# **CHIPPENHAM WITHOUT PARISH COUNCIL**

## **STATEMENT OFH2 Tuesday 30 June 2026**

### **LIME DOWN SOLAR PARK – EN010168**

Title:
Figure 3-2-6: Key Construction Phase Features
Cable Route Corridor

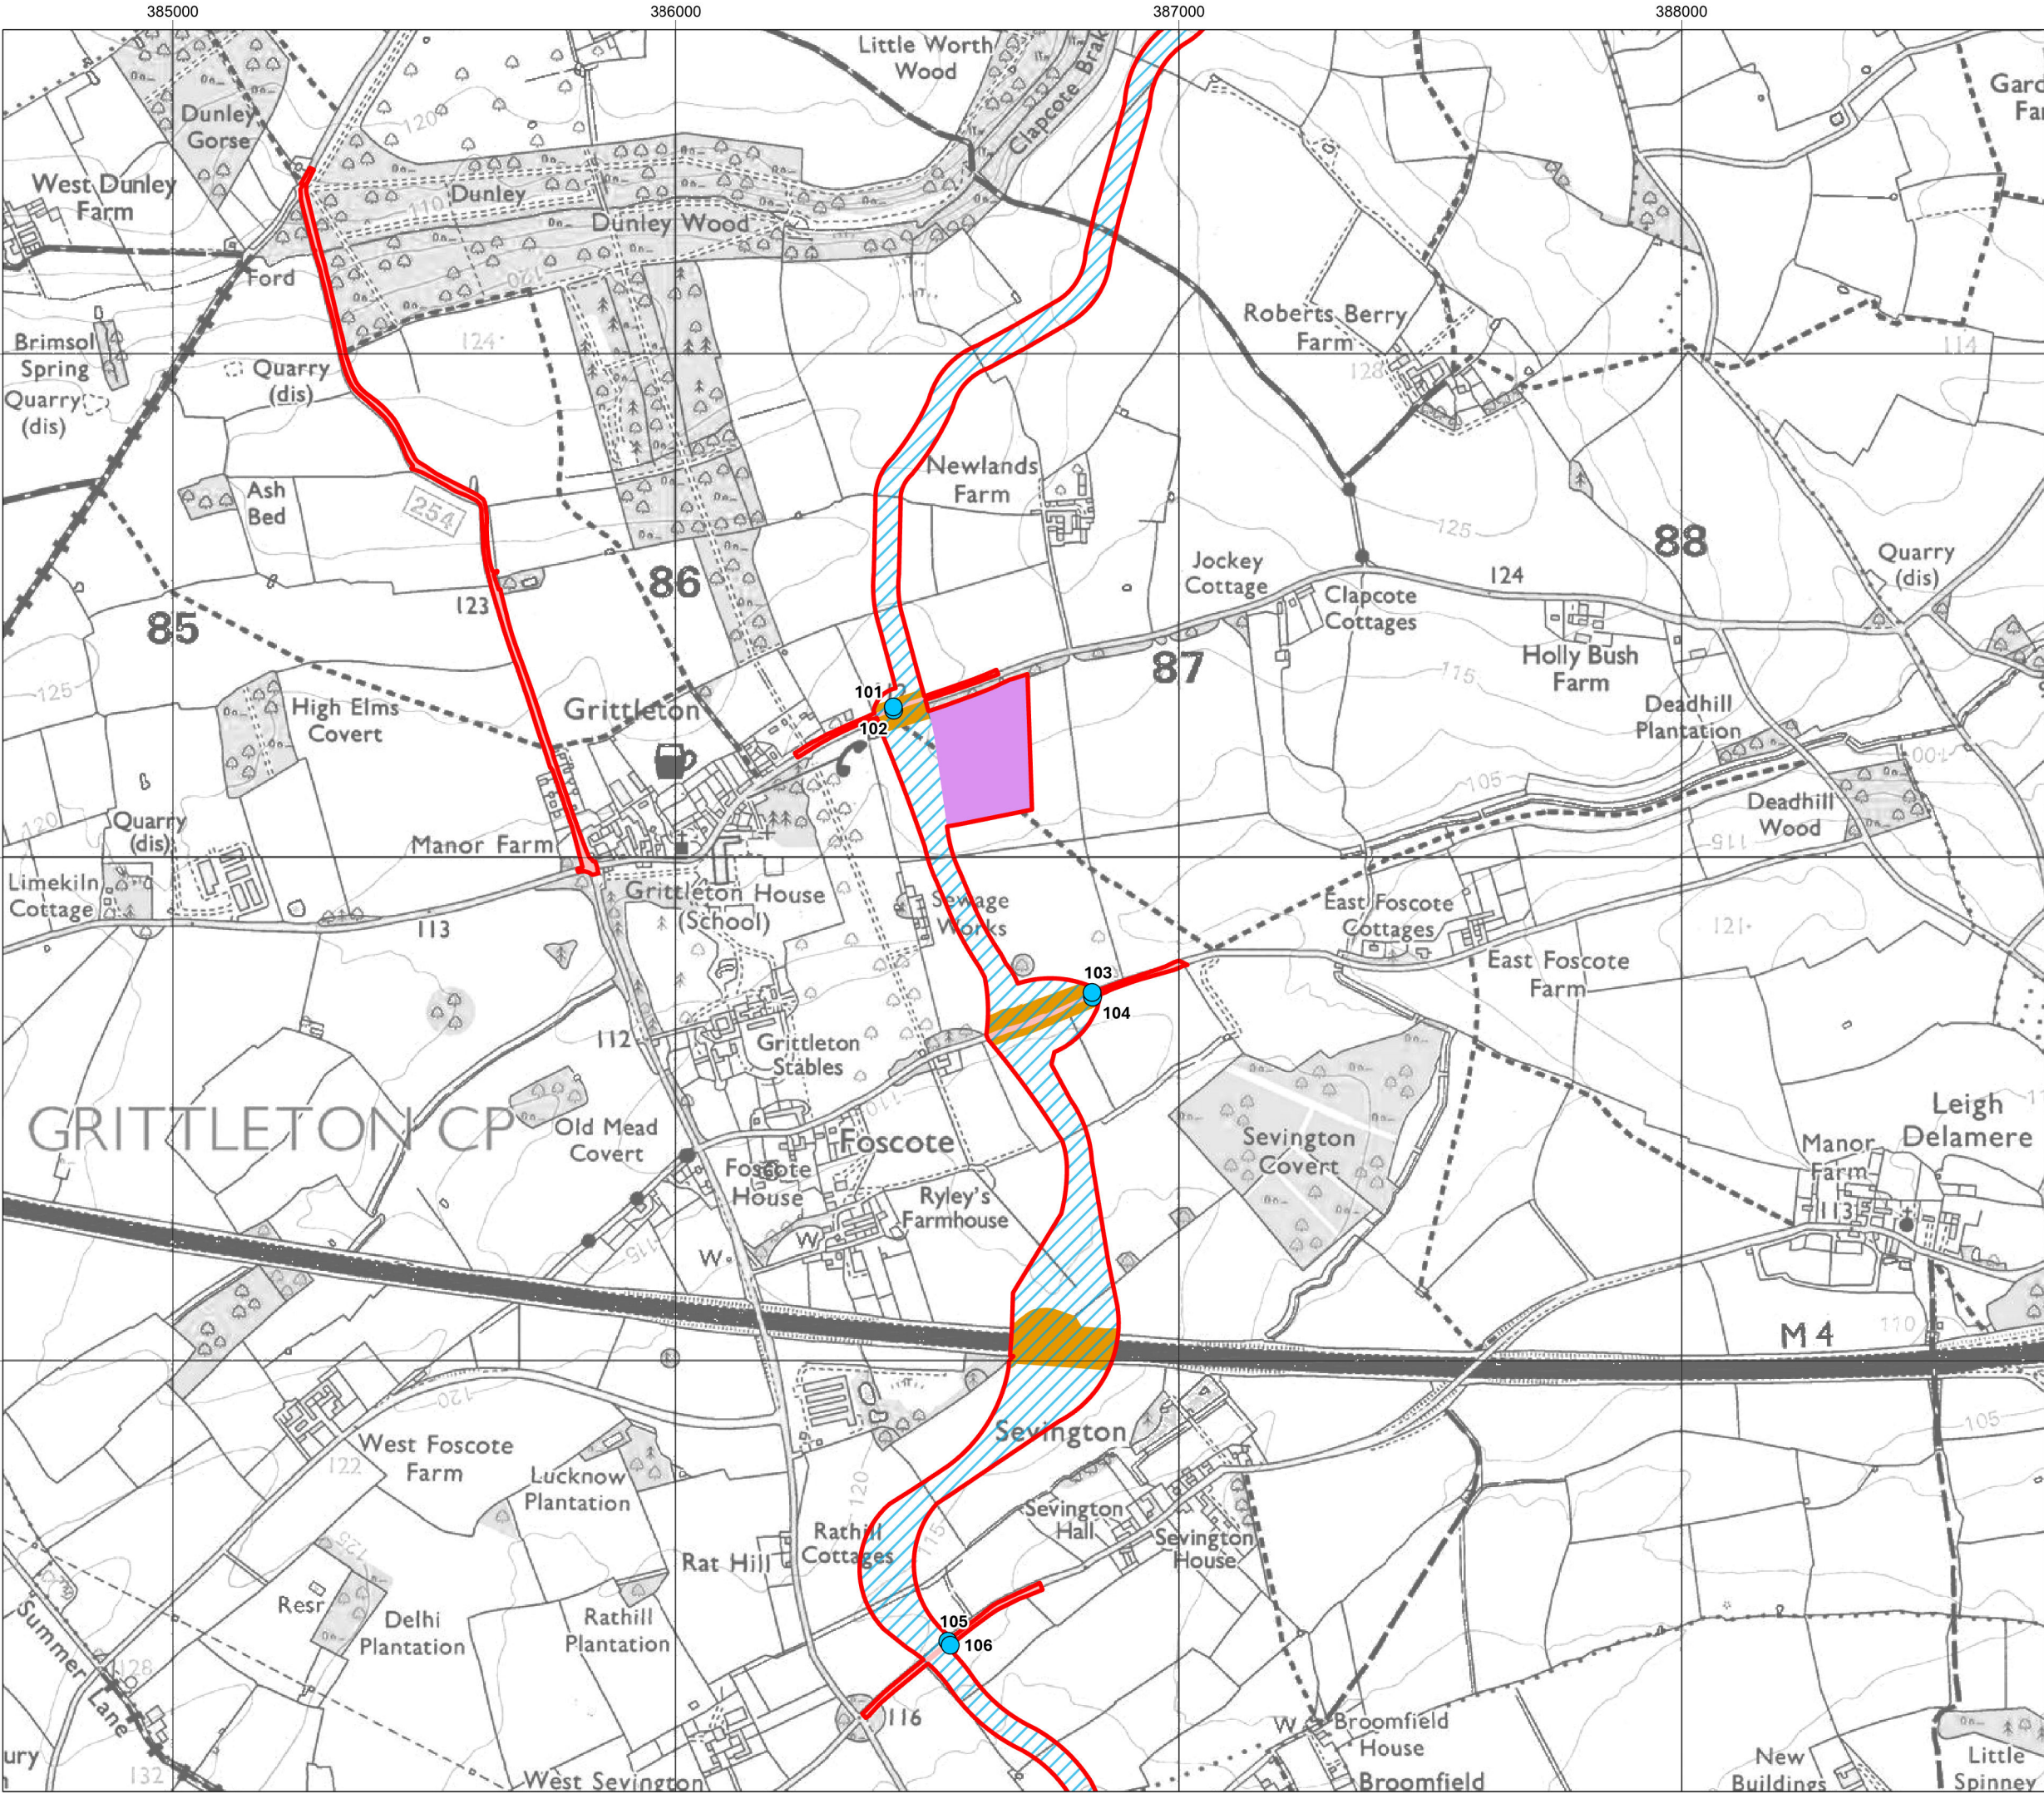
The Council is concerned about two particular aspects that have severe highway implications for the Parish that relate to the favoured cable route from the solar park to the grid connection at Melksham. This route would run through parts of the western boundary of the Parish affecting also the adjoining Yatton Keynell, Biddestone and Corsham Parishes.

It is understood that to support the cable laying activity it is planned to have two operation support sites for managing the excavations, and the parking and maintenance of plant and trucks.

One site is within the Parish in the field bordered by Fowlswick Lane and the B4039, the through route from the A420 to Yatton Keynell, with the Golf Driving Range to the North. (DWG. B supplied identifies this)

Access to this field is proposed from Fowlswick Lane about 200 metres from the existing crossroads. The proposed opening serving an access track will require considerable enlargement and metaling, as will the Fowlswick Lane itself, which would need to be widened down to the crossroads. (Identified yellow on DWG. B)

This will potentially require the removal of the mature hedgerow along the 200 metre length with verge and also have highway drainage implications. The existing crossroads is a known accident black spot and is far from ideal for use by plant and heavy vehicles.

The other potential access to this field is proposed to be directly onto the B4039, on the western boundary of the field, which is also a traffic hazard and which will require a large splayed access, with significant visibility splays and signage and a reduction in speed limit. (Identified green on DWG. B)

It is considered that if either access proposal was adopted the entire length of mature hedgerow on the B4039 in the northern direction would need removal and replaced along a new visibility line to the crossroads. The change in landscape of this rural area required by these works to facilitate a safe highway arrangement would have significant detrimental impact on the overall character of the area.

Title:
Figure 3-2-9: Key Construction Phase Features
Cable Route Corridor

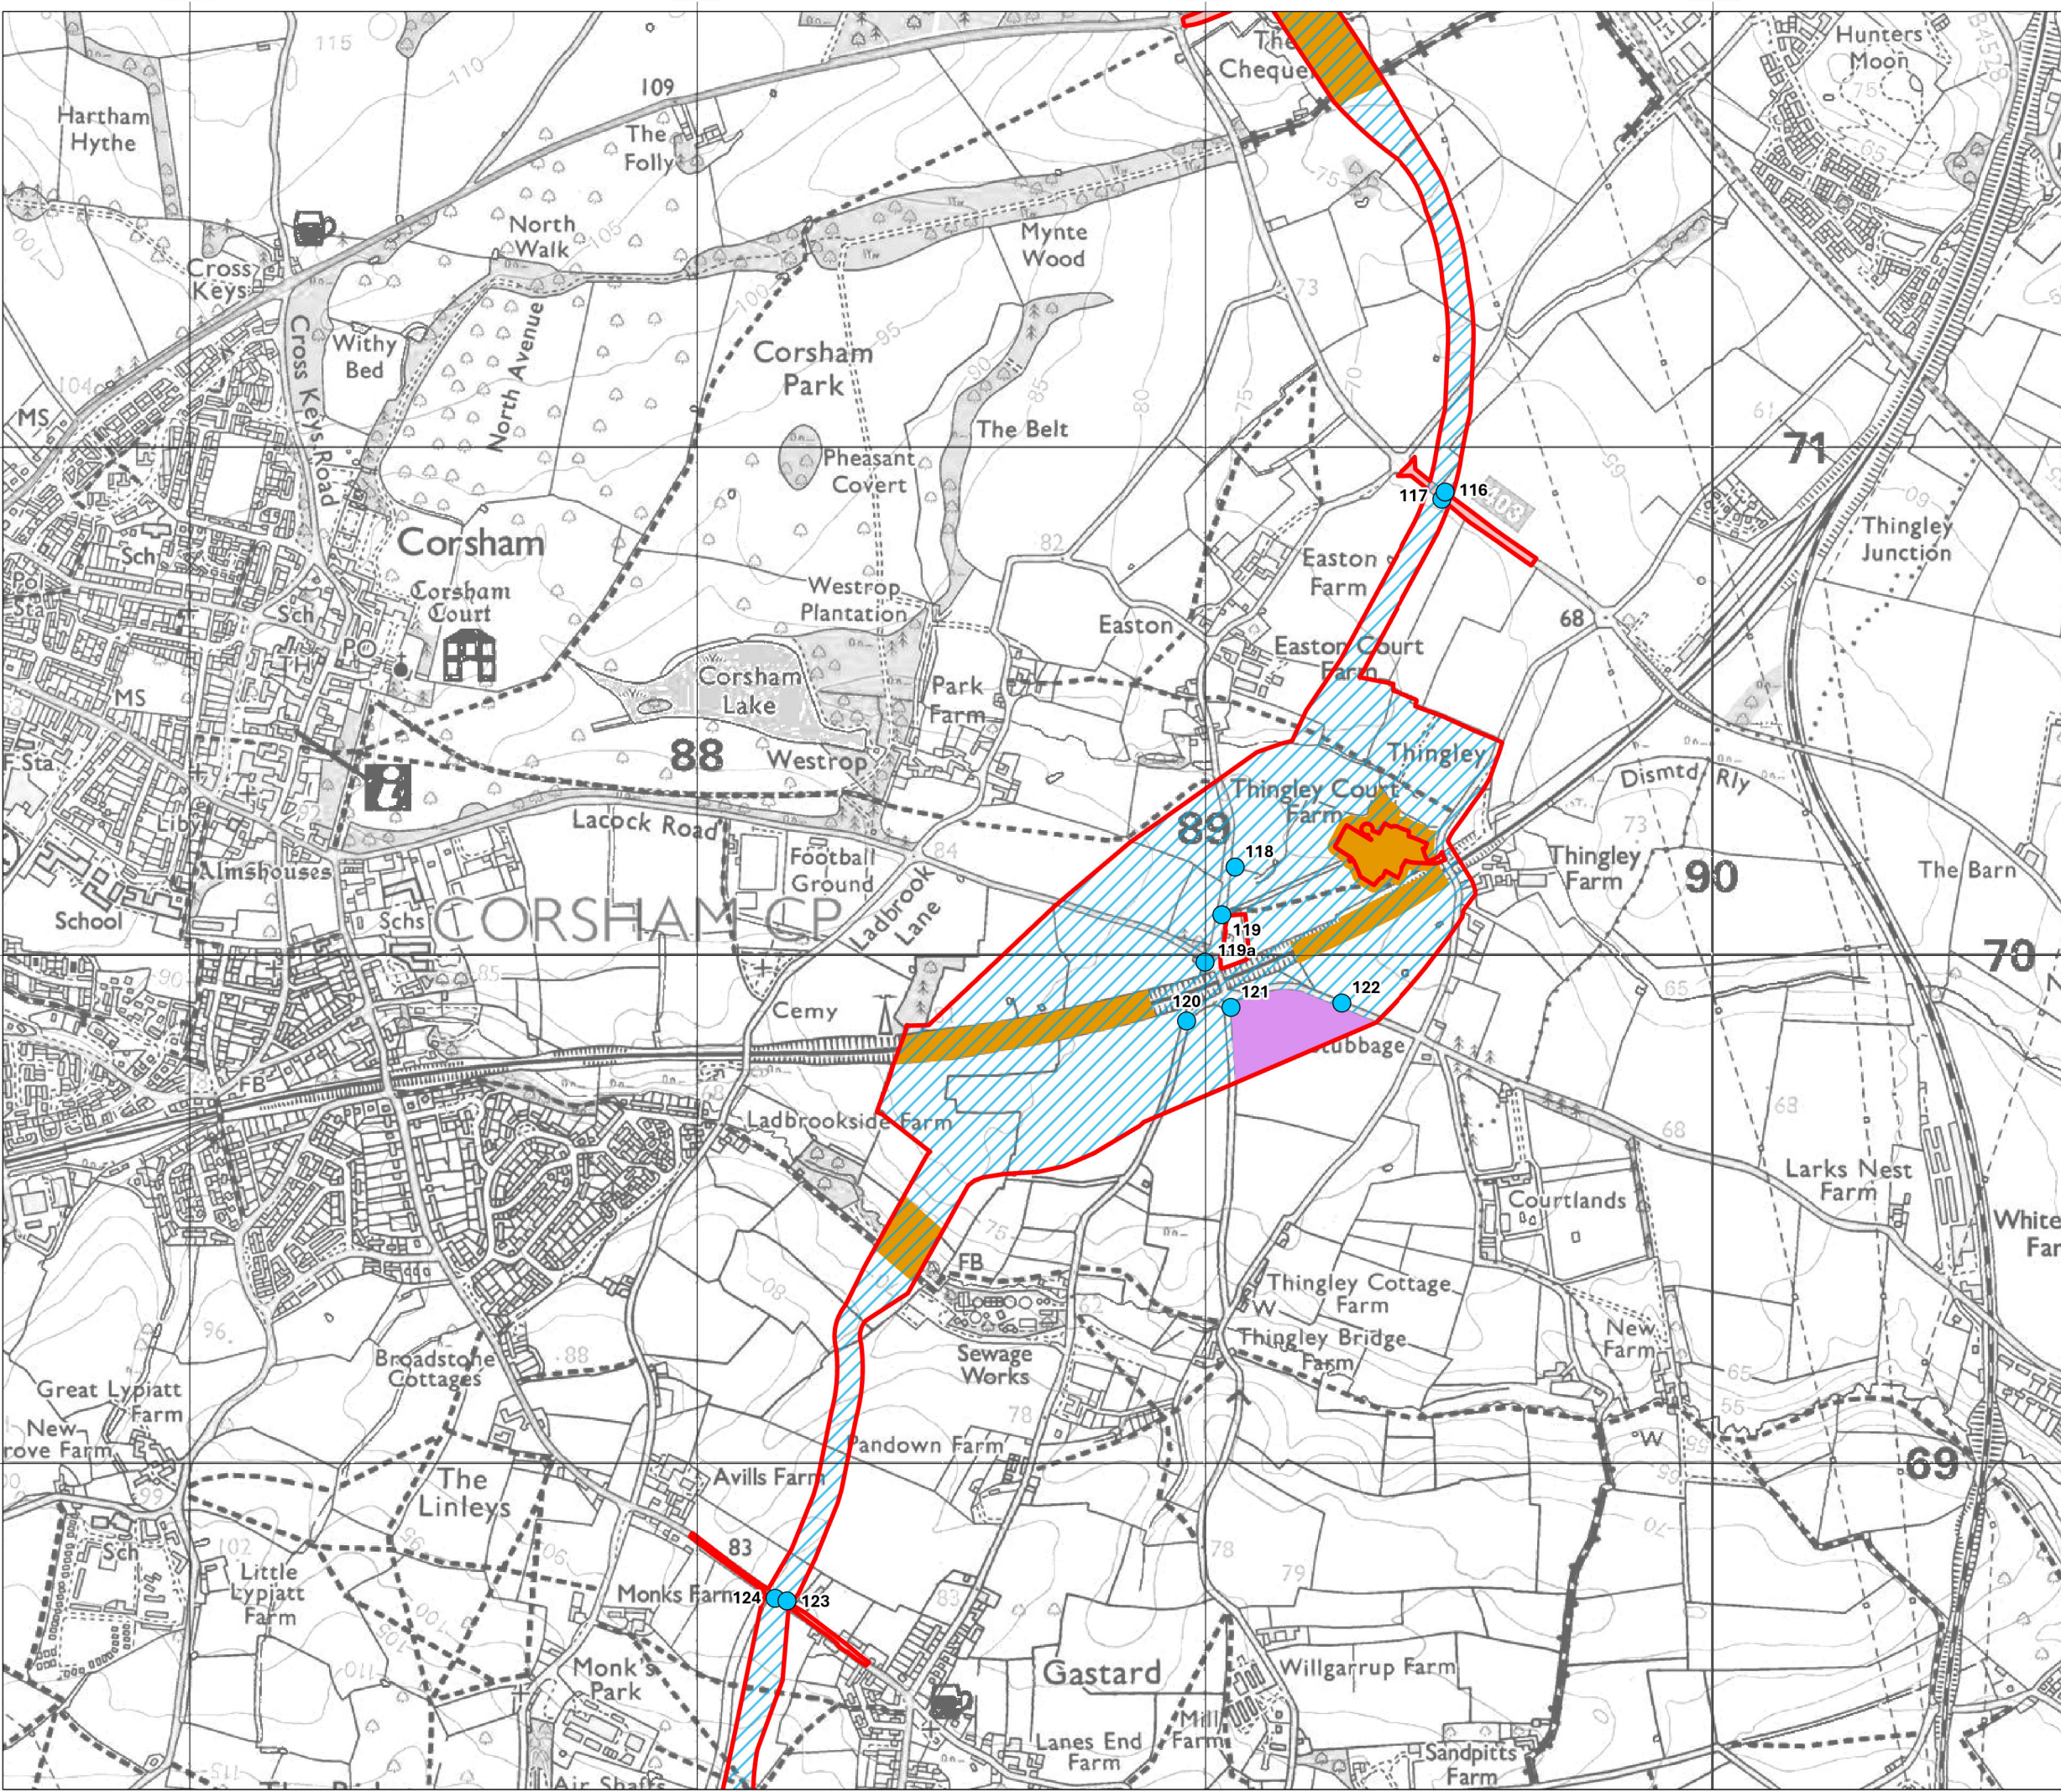
The second proposed site borders the Parish in a field opposite Showell Farm, not within the Parish, but the problem here is again one of access, which will have to be off the narrow Corsham Lane. (DWG. A supplied identifies this)

However, Chippenham Without Parish has a significant interest in that the route to and from the proposed site is likely to be along Corsham Lane via Sheldon Corner and the A420 Allington Farm crossroads. (Identified yellow on DWG. A) The reason being that while the access using the Corsham Lane off the A4 is feasible for large construction traffic, exiting back on to the A4 would be difficult and extremely dangerous. (Identified green on DWG. A)

Consequently, as other narrow country lanes towards Chequers Farm and Biddestone are entirely impractical for heavy use, it is considered that access to this site would therefore have to be through the Parish. Thus, there will be considerable highway safety implications and potential disruption to this often rat run narrow artery of the Parish especially at the joining local lane junctions, the Sheldon Corner blind spot and the A420 Allington Farm crossroads which will be totally unacceptable from a highway safety point of view as all are existing accident black spots.
